Application Reference: 6/2023/0497/COND

Proposed development at: 61 The Ridgeway Cuffley Potters Bar EN6 4BD

Proposal: Submission of details pursuant to condition 2 (samples of materials) on planning permission 6/2022/2586/HOUSE

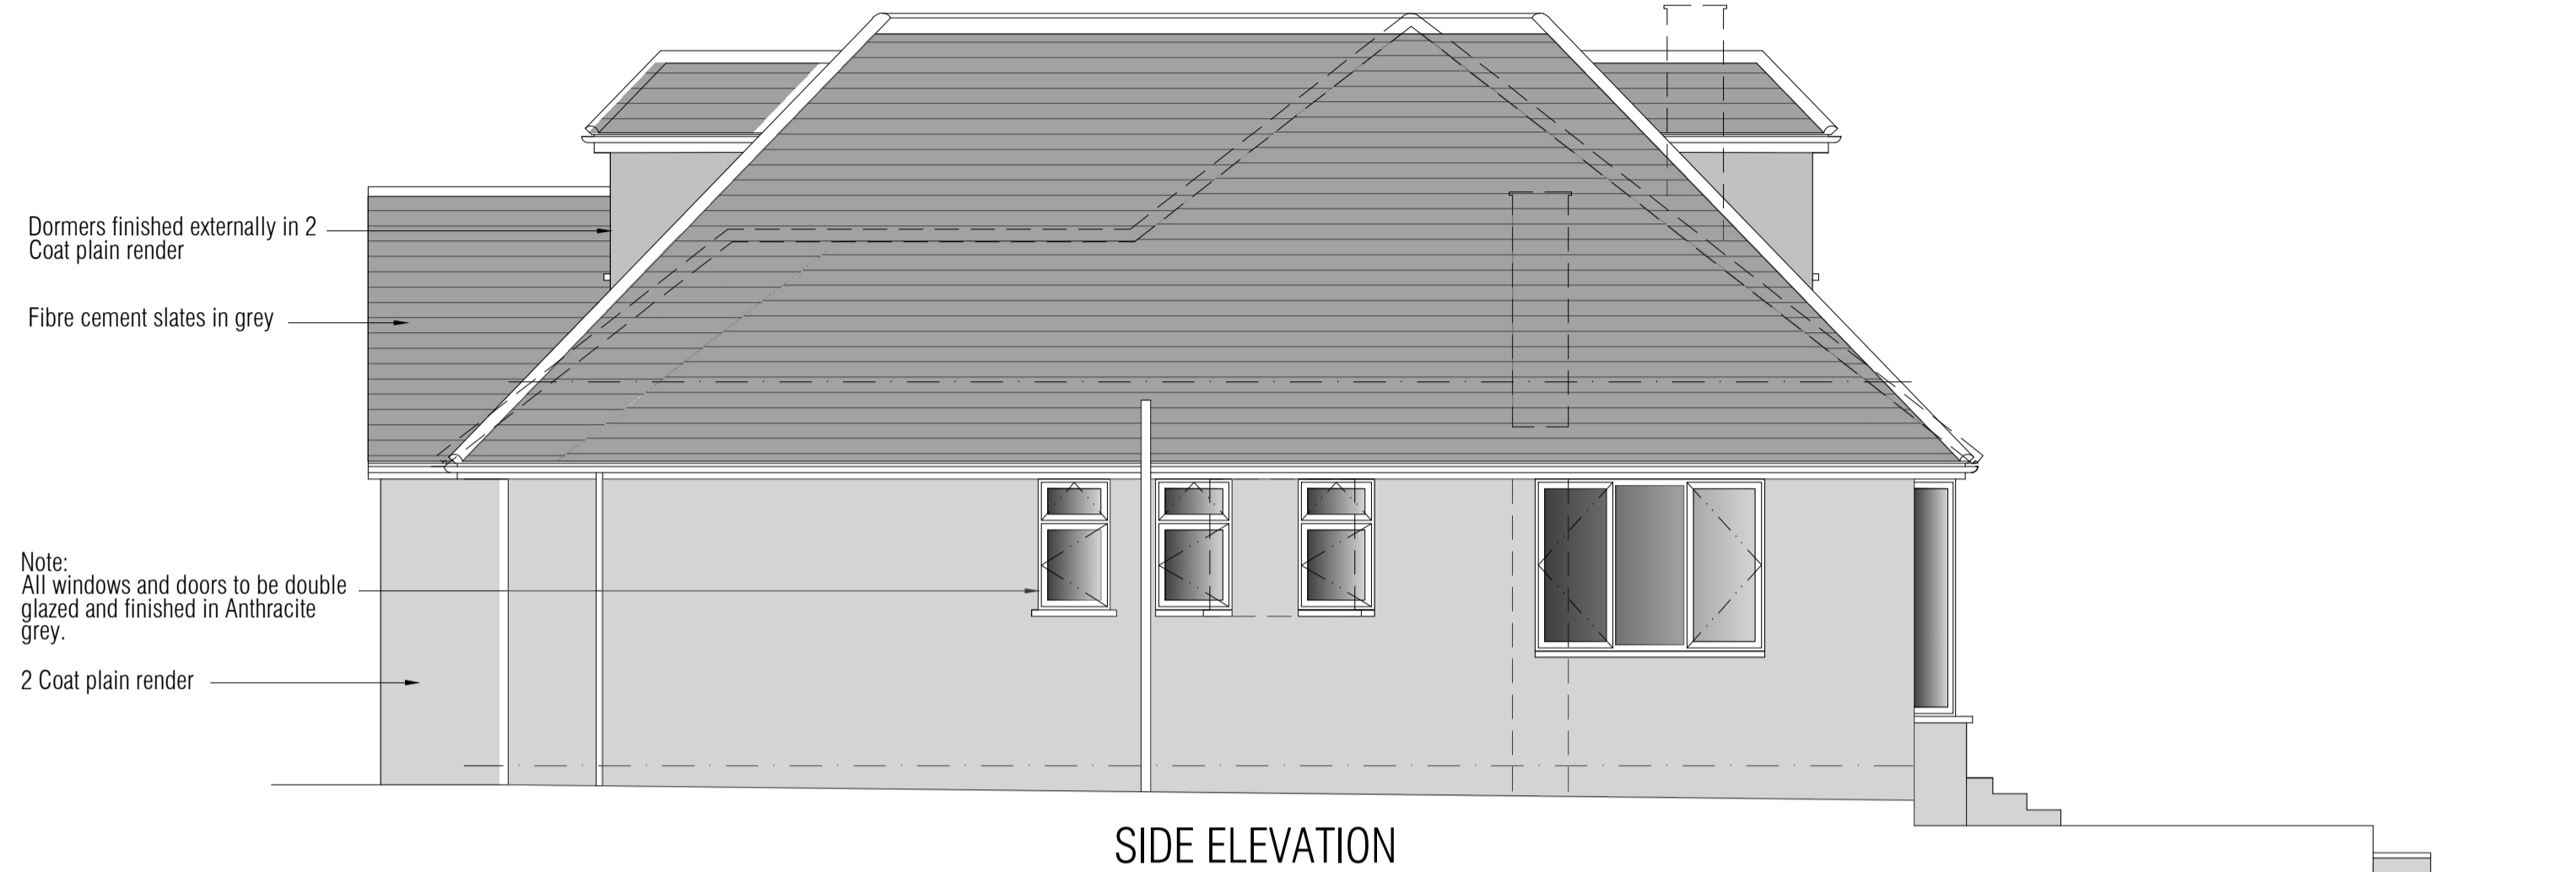
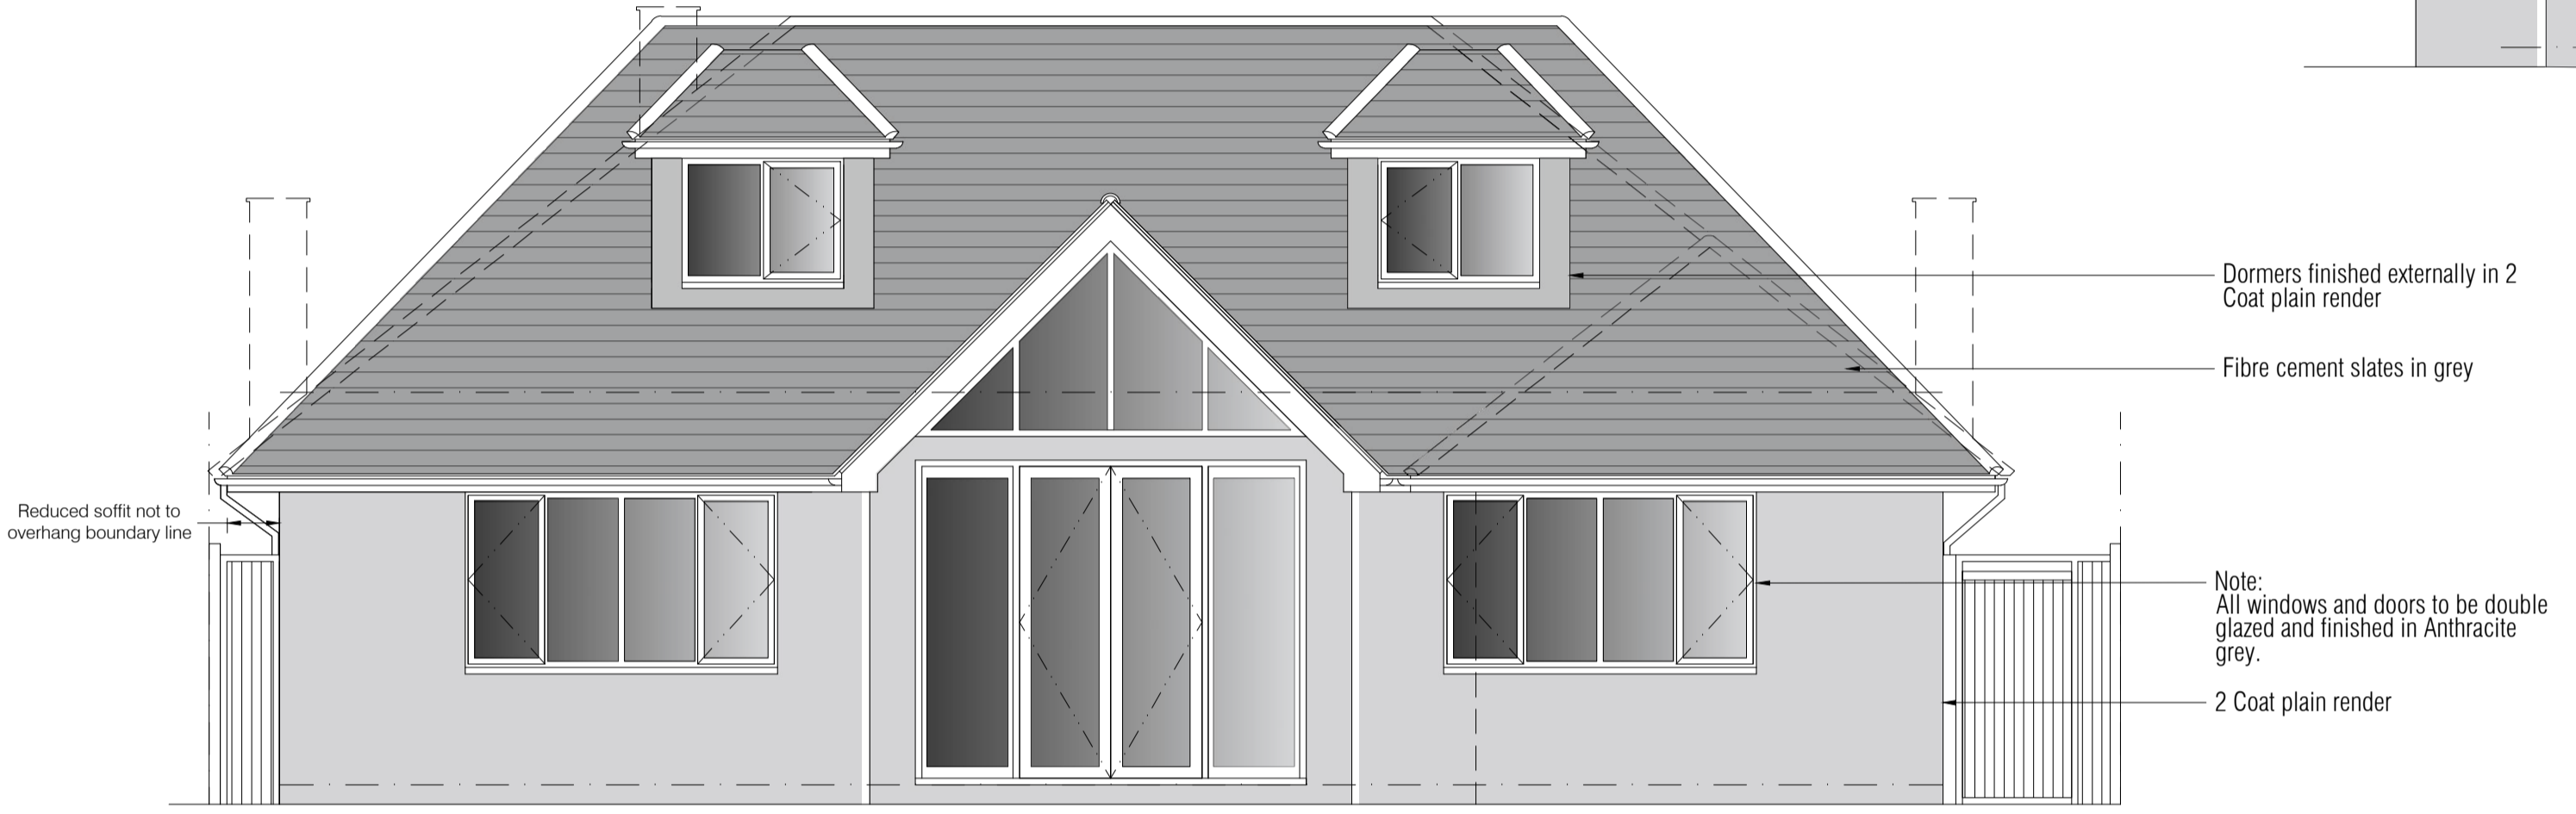
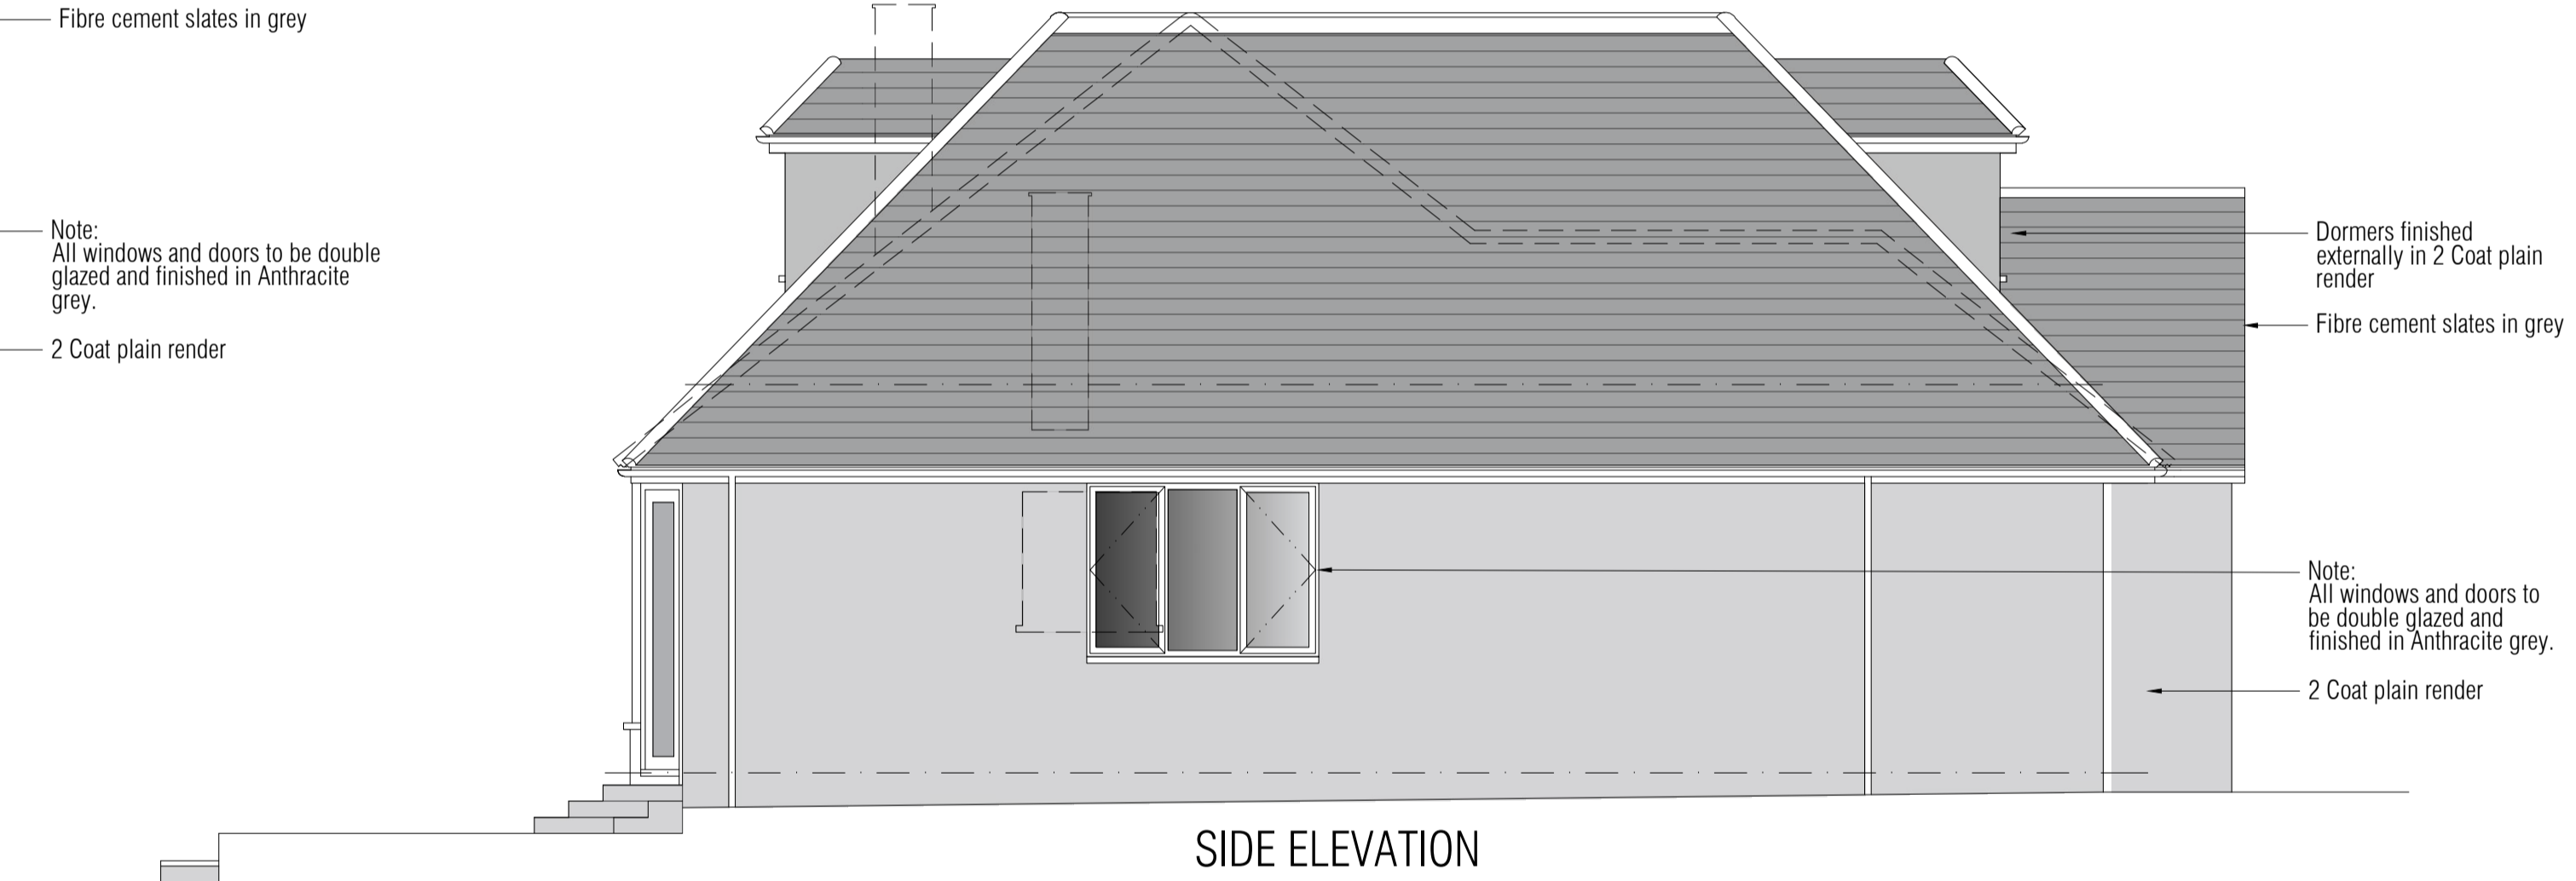
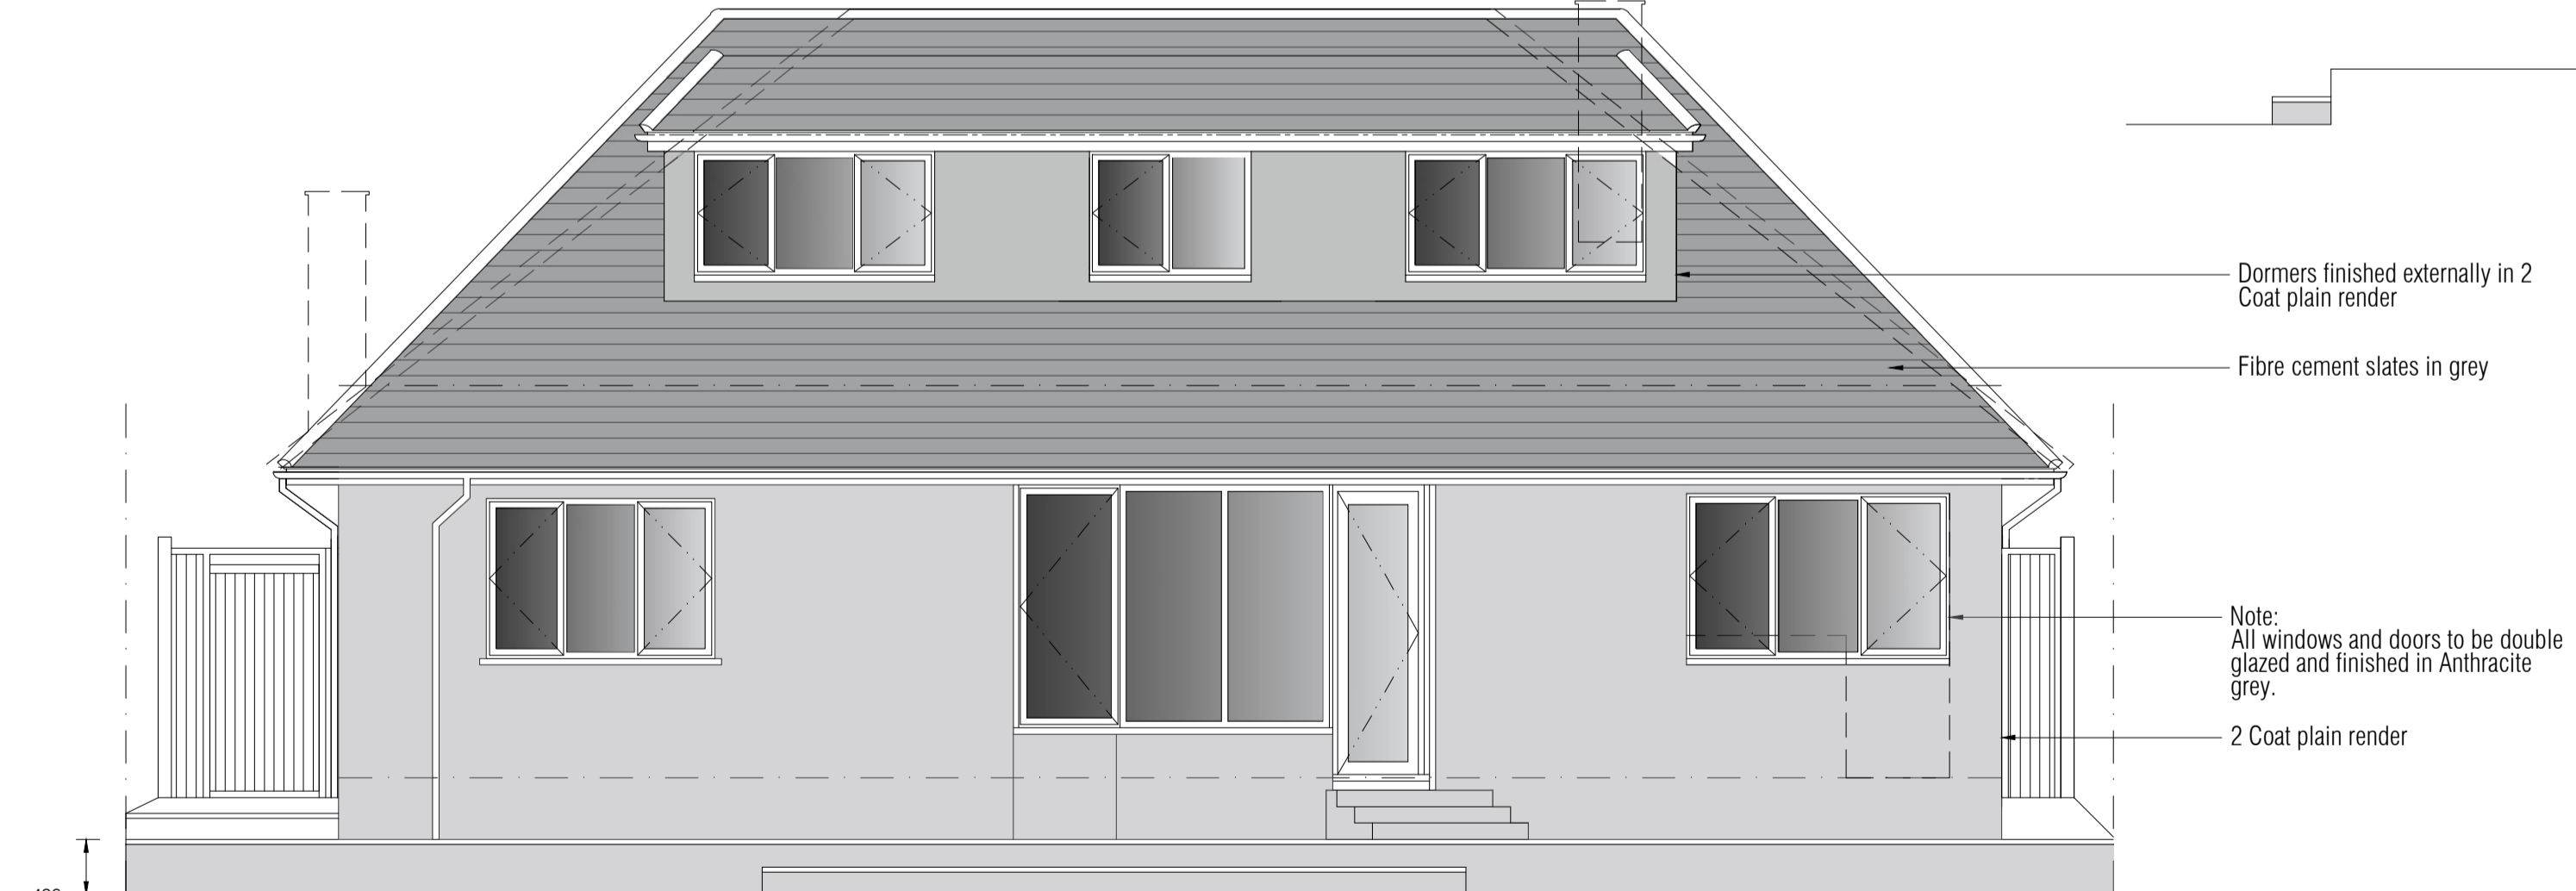
Submitted with this application is drawing 105 D which demonstrates the proposed elevations for the site with annotations of the proposed materials, as well as

- Cambrit Jutlan Fibre Cement tiles in the colour graphite
- Weinerberger Concrete Multi Angle Ridge tiles in dark grey
- Flavent Rainwater Parapet Outlets in black
- Sopratorch SL400 Flat Roof cap sheet
- Fascia, soffit and verge boards in square edged jumbo design in anthracite grey
- K-Rend 2 coat plain render in Limestone White
- uPVC residence collection R7 windows in Eclectic Grey

Having regard to the above, I am pleased to confirm that sufficient information has been submitted pursuant to the requirements of condition 2. Please note that the development must not be carried out other than in accordance with the approved details unless otherwise agreed in writing by the Local Planning Authority.
